# CITY OF ALBUQUERQUE

December 1, 2017

RE: **Montessori on the Rio Grande Charter School**  
**1650 Gabaldon Dr NW**  
**Grading and Drainage Plan**  
**Engineer's Stamp Date 10/13/17**  
**Hydrology File: H12D008B**

C102

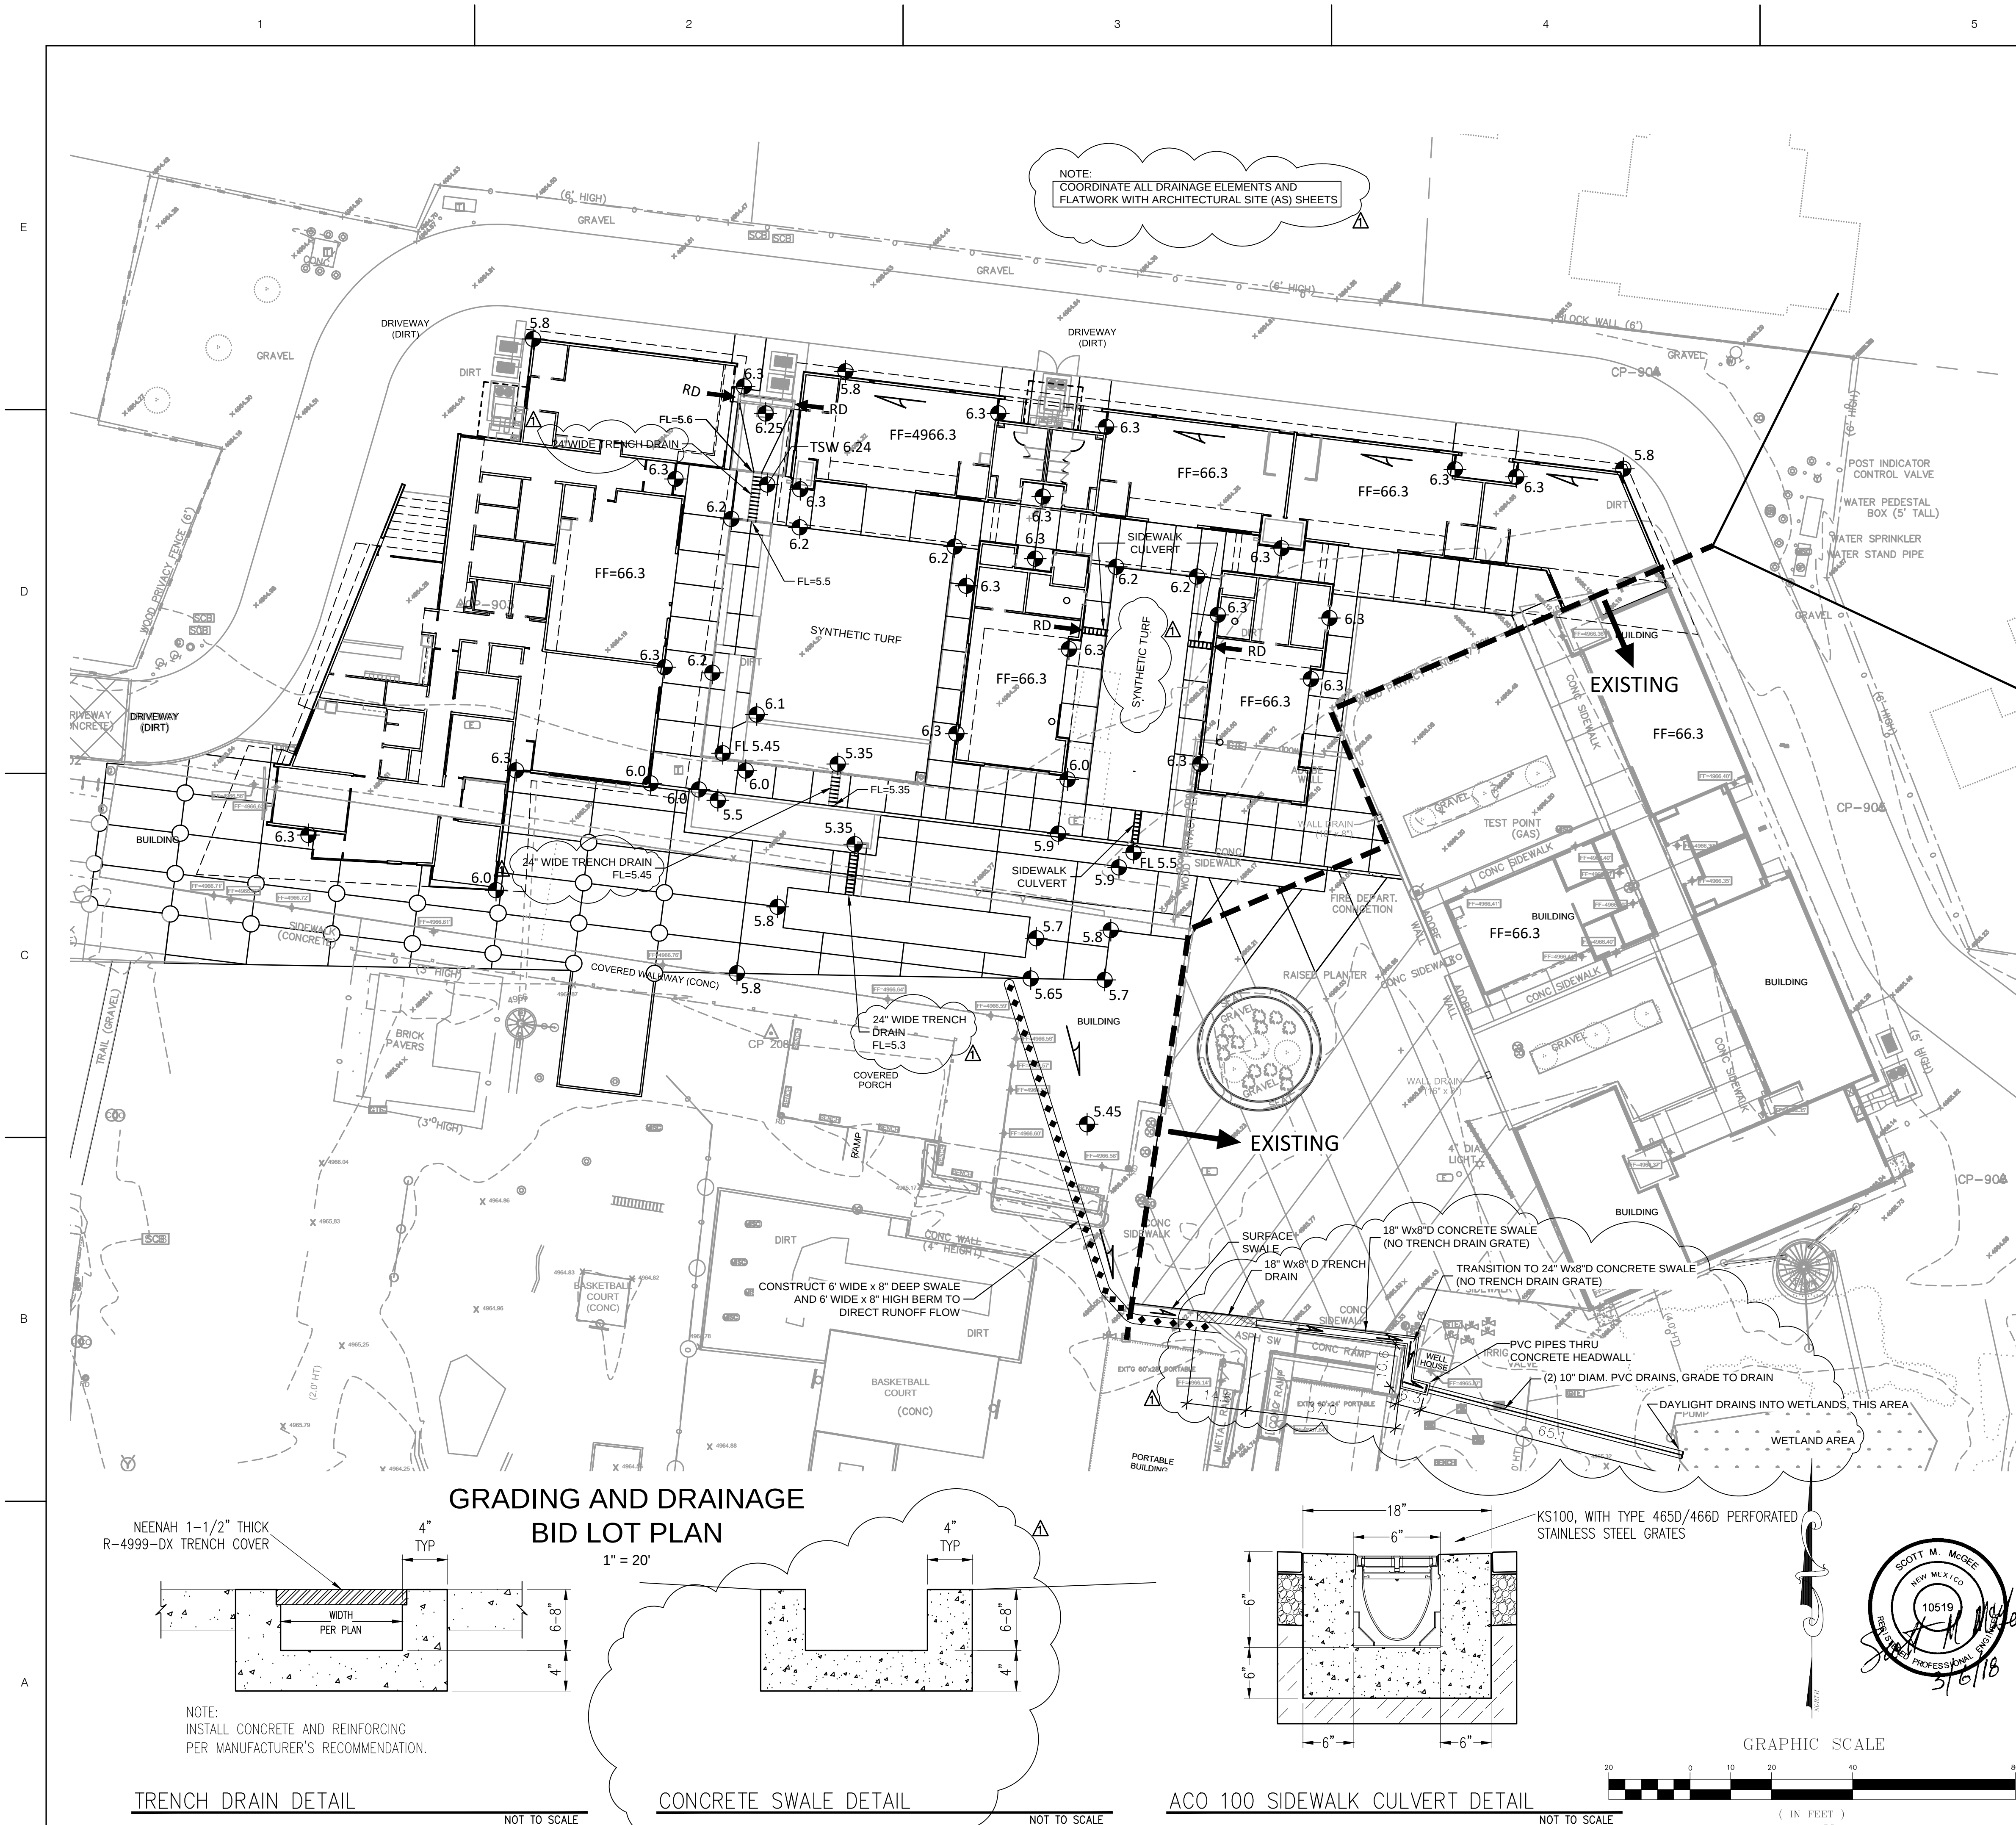
4. Where does drainage go now? Show where the 100-yr run-off goes now for the entire school (the existing buildings on the south, the west parking lot, and the dirt lot to be built on).
5. Where will runoff go once the proposed improvements are complete? If there is no adequate outfall (typical in the valley) the 100-year, 10 volume must be ponded on-site.
6. It appears that this project will bring in fill and raise grades by 1-2' in the dirt lot. Combined with the increase in impervious area here, Hydrology is concerned about the effect on the neighboring residences to the north. How will this project affect these properties?
7. A separate drainage plan encompassing just the hydrology aspects is recommended to address these concerns and to support the grading plan.
